**From:** [REDACTED]  
**Sent:** 12 March 2023 20:15  
**To:** Planning  
**Subject:** Planning Application Ref 3/2022/1181 – Cherry Hall, Main Street, Grindleton  
**Categories:** xRedact & Upload

### **Planning Application Ref 3/2022/1181 – Cherry Hall, Main Street, Grindleton**

Drawing Title
Proposed Plans, Section A-A and Elevations

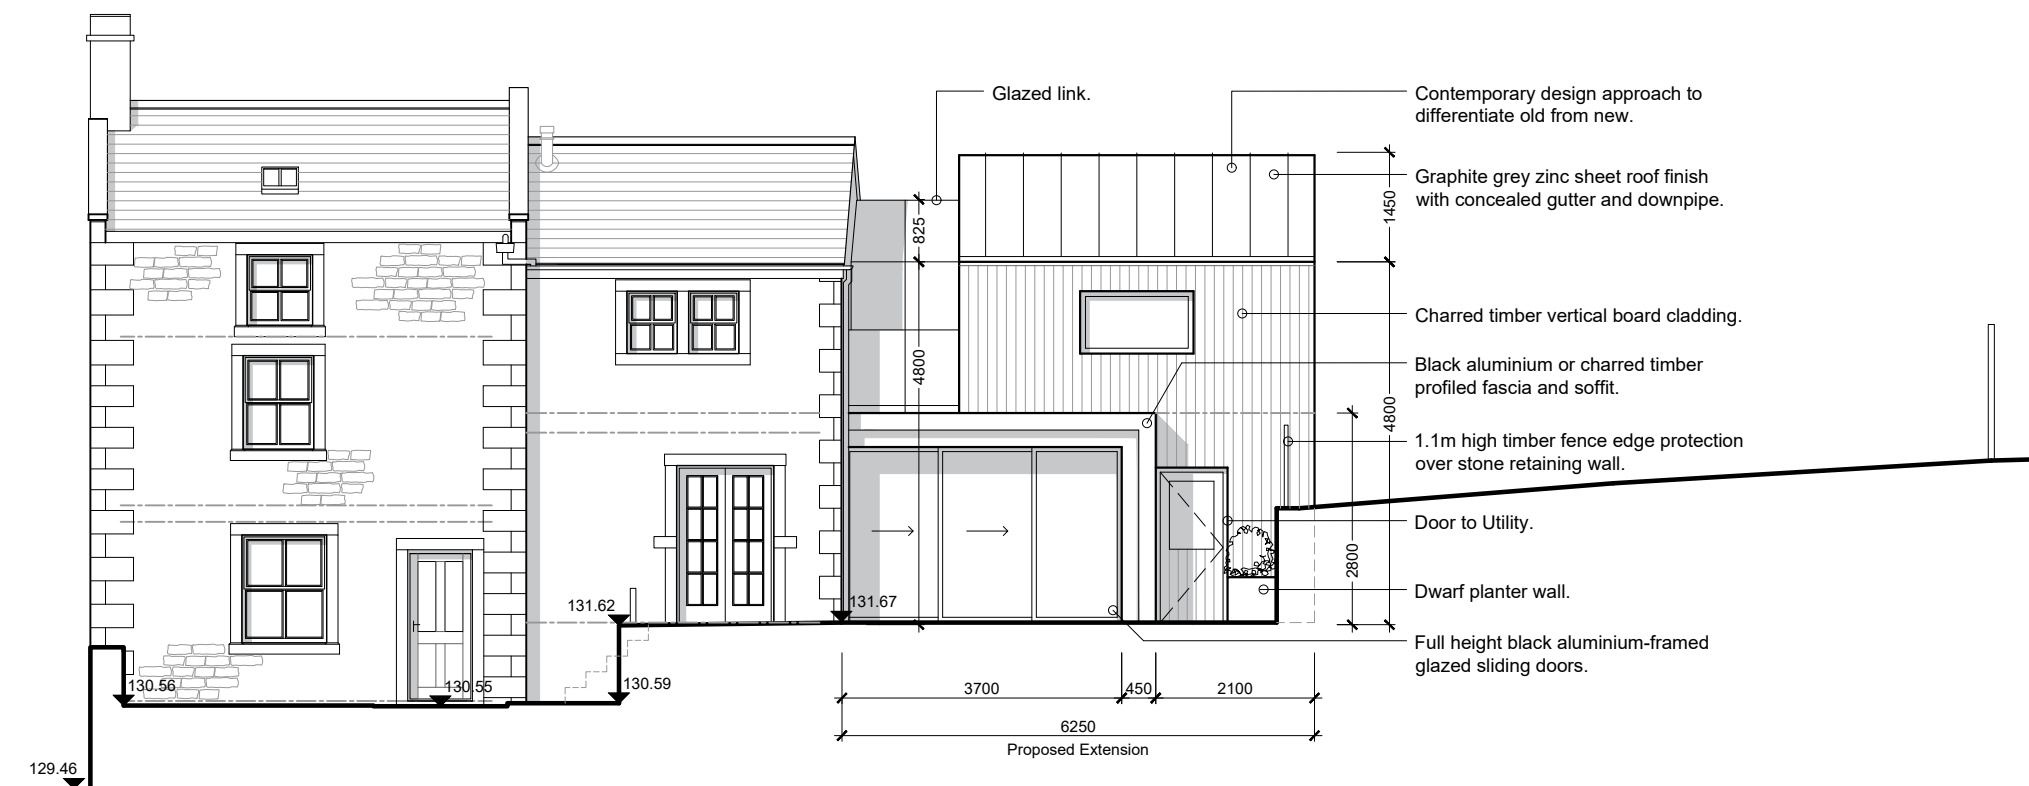
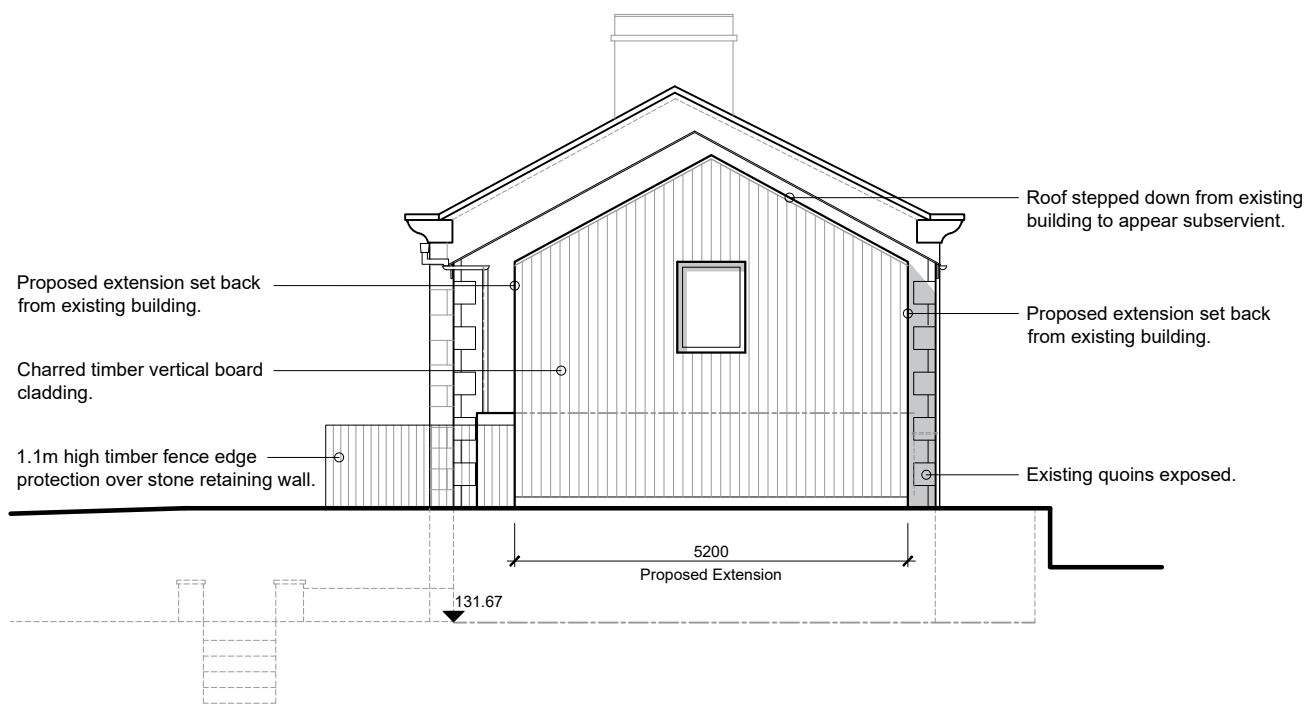
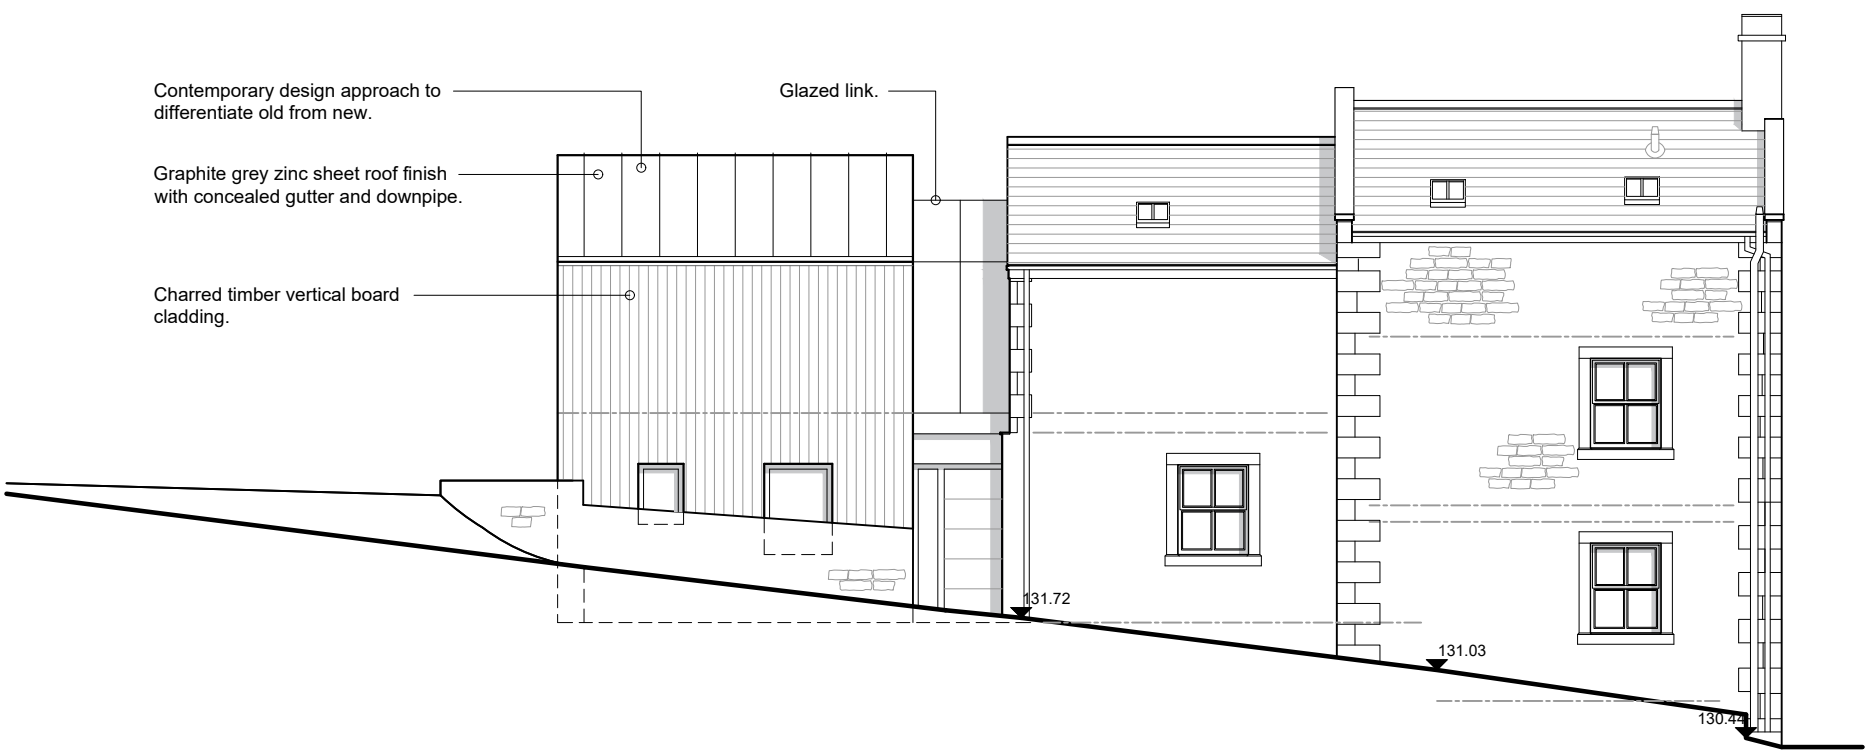
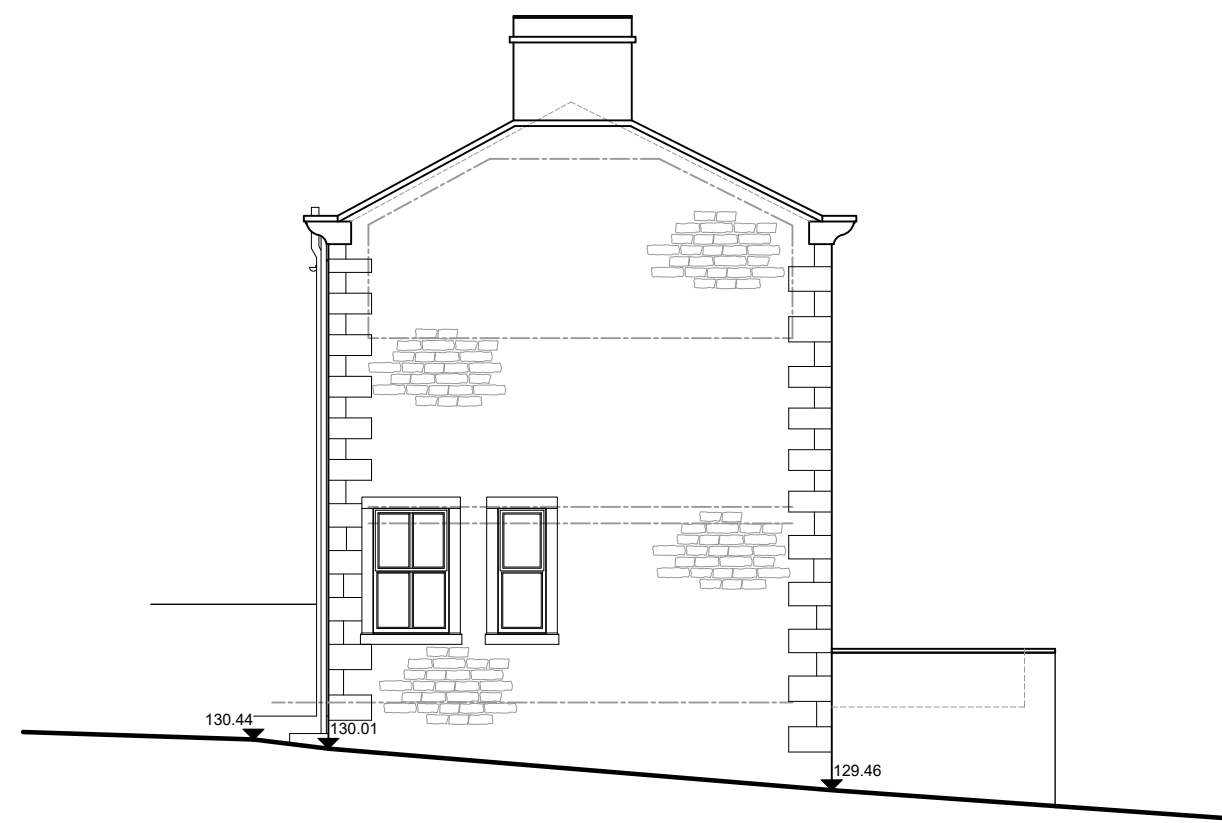
Materials - as stated above the drawing proposes the adoption of graphite grey zinc roof, black aluminum and charred timber board cladding and a glazed link. In my opinion the use of these materials is out of character for the neighborhood, ignores local design guidelines and will be aesthetically displeasing in this context.

The drawing shows the existing boundary wall being retained along the south of the track. However, given the extent of excavation required to construct the new 1m high stone retaining wall immediately alongside the existing wall, it is almost certain that the existing wall will need to be demolished and rebuilt, resulting in a loss in character. The Grindleton Conservation Area Appraisal states that boundary walls are a distinctive feature of the conservation area.

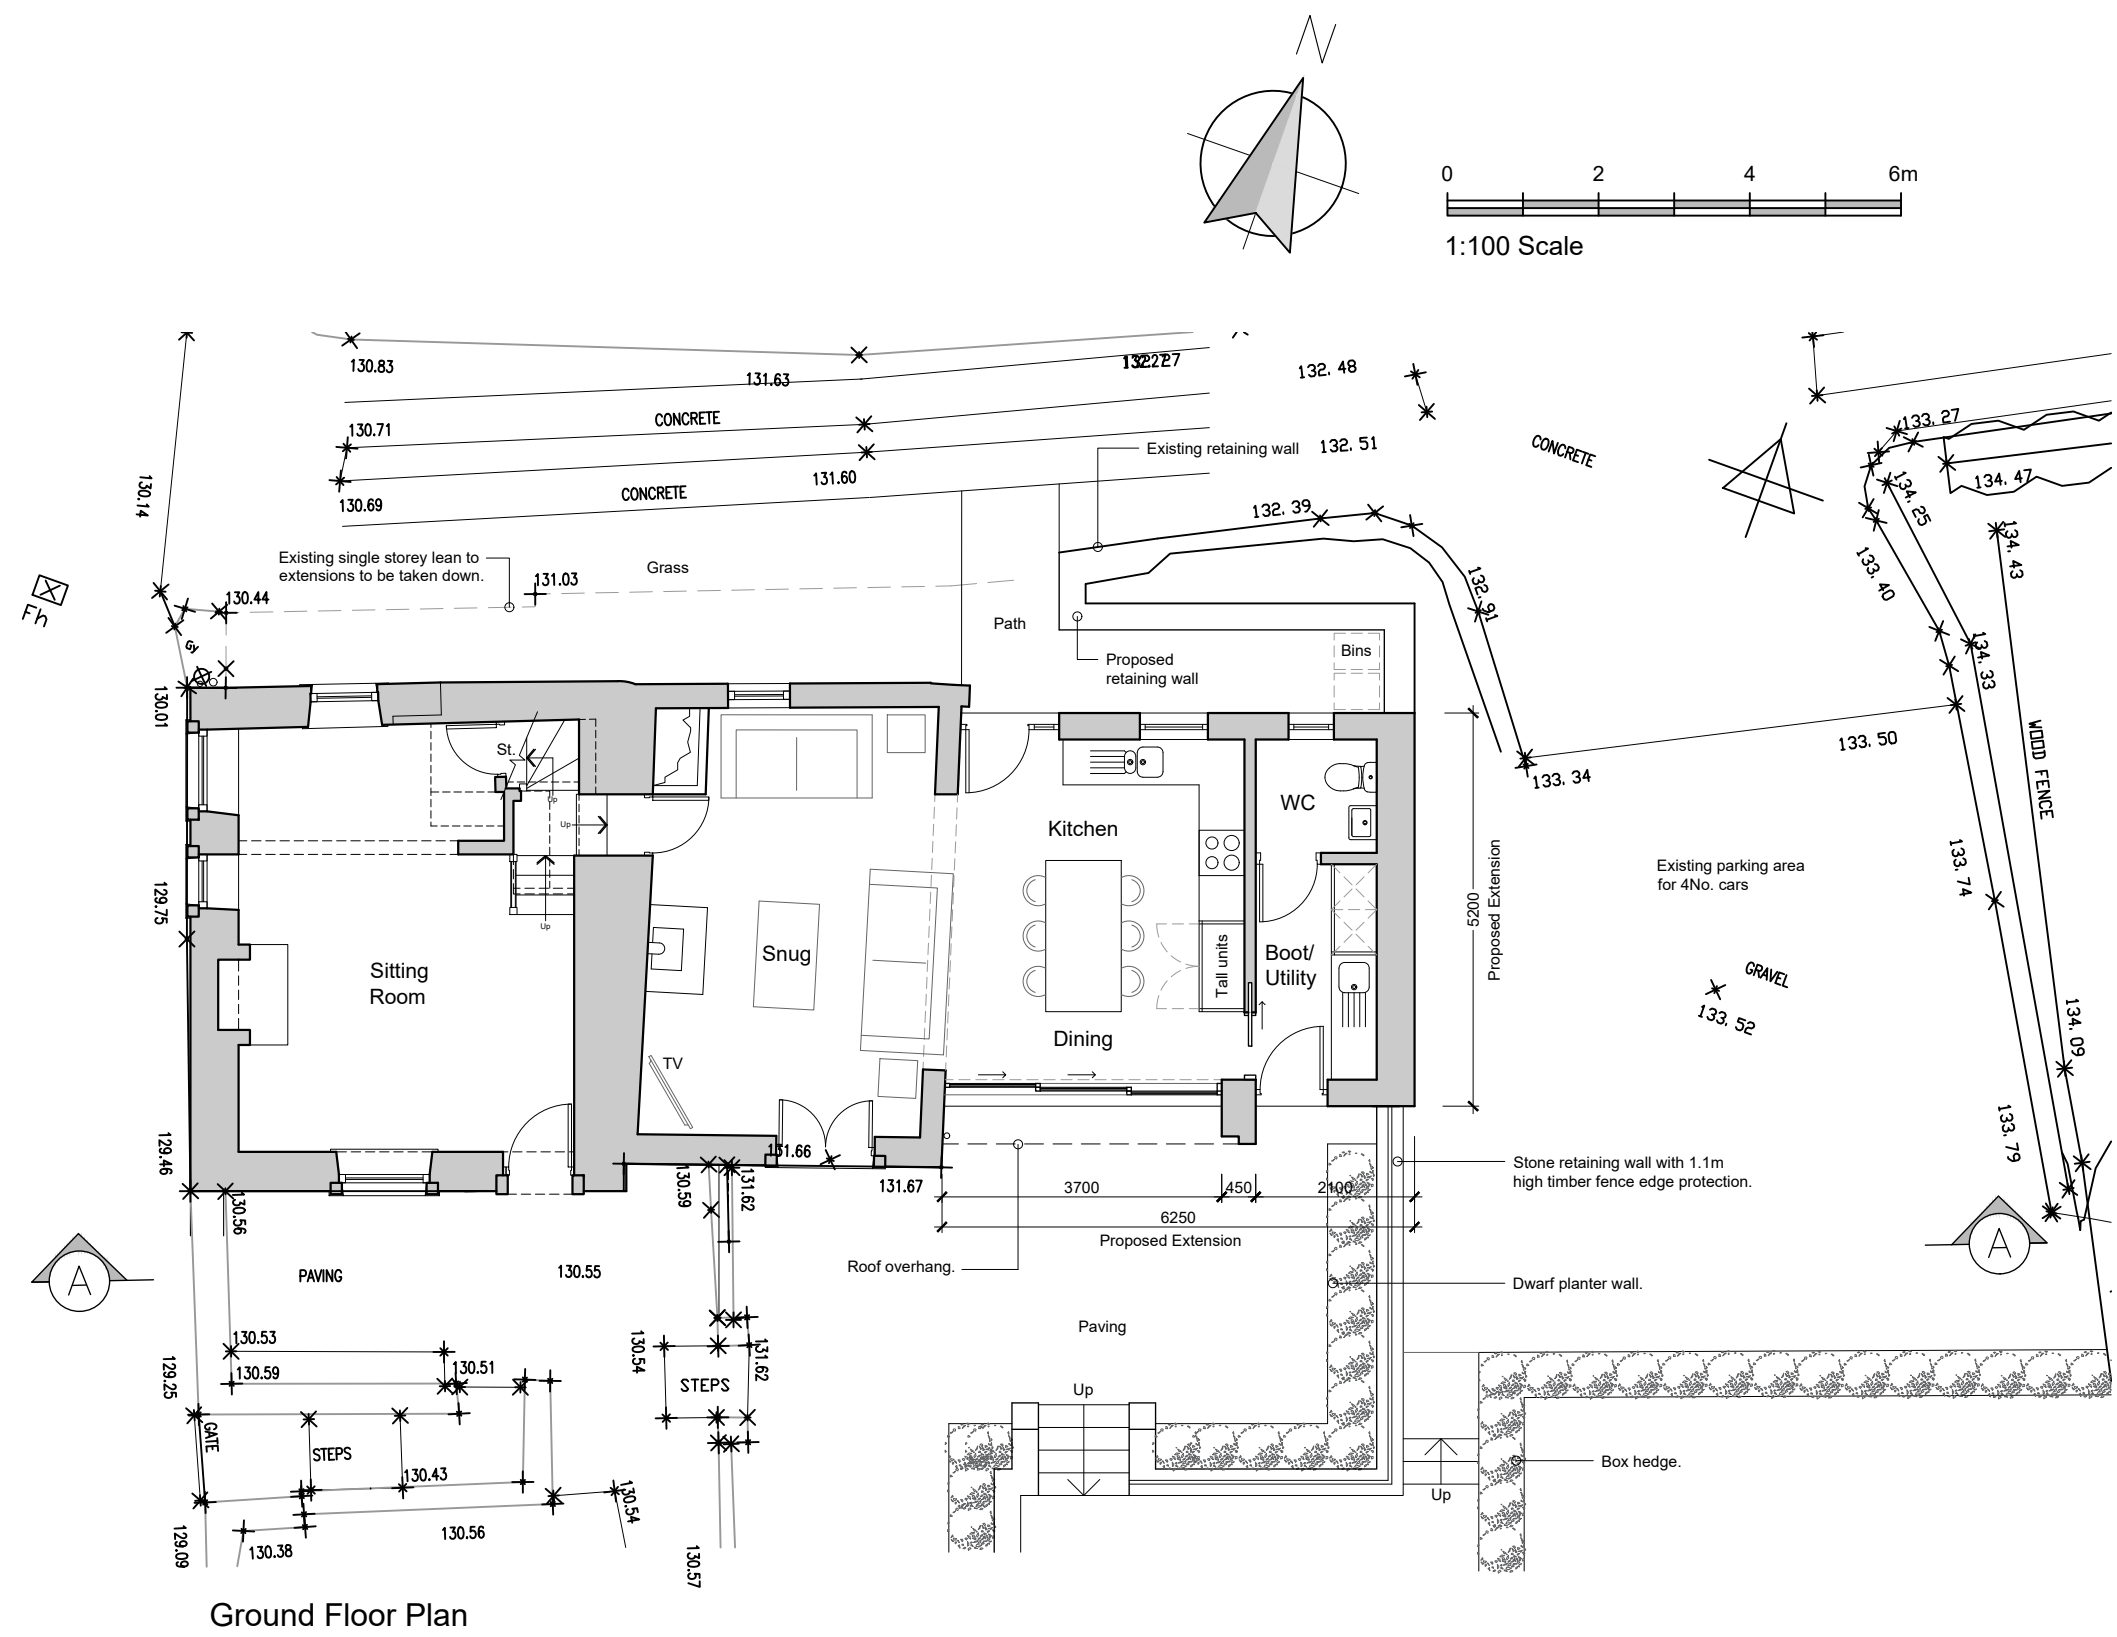
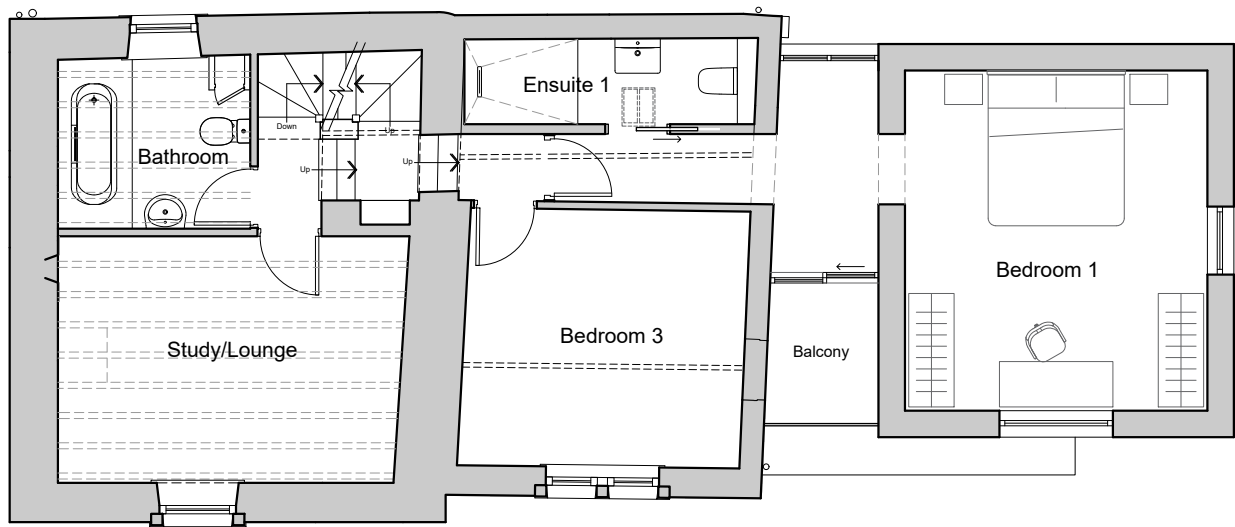
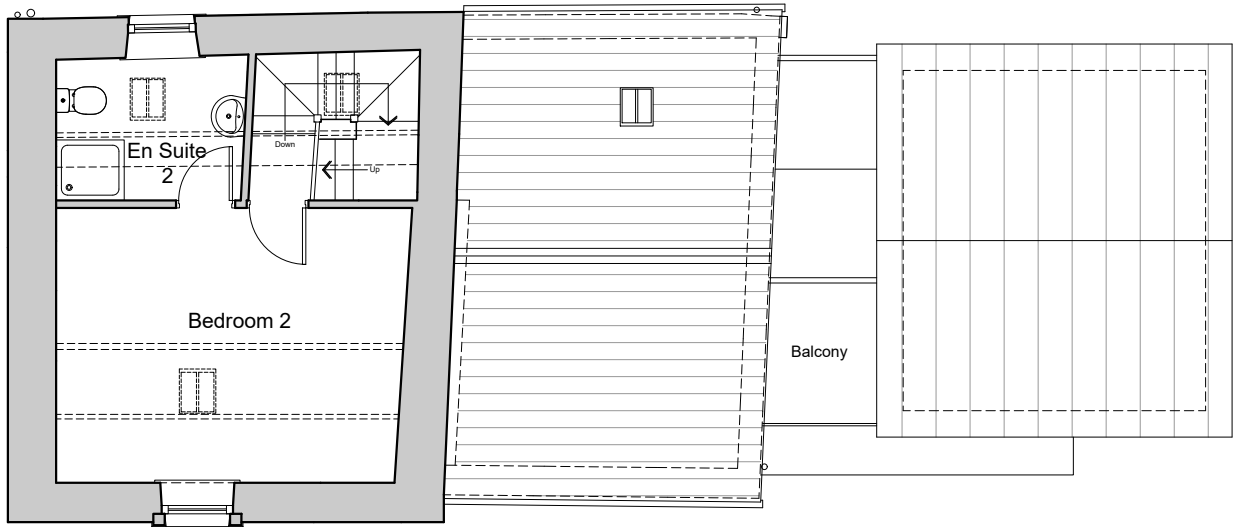
At present [REDACTED] by one window on the [REDACTED] of Cherry Hall, the proposed development will result in an additional four windows and the glazed link at first floor level [REDACTED] This will result in a [REDACTED]

- The fully glazed link is intended to provide a “visual degree of separation between the old and the new”. This implies that it will be unobstructed and therefore ‘transparent’ however it separates the bed and the bathroom within an en-suite bedroom! I do not believe that in use it will achieve the objective set out in the 2nd para of 6.1.
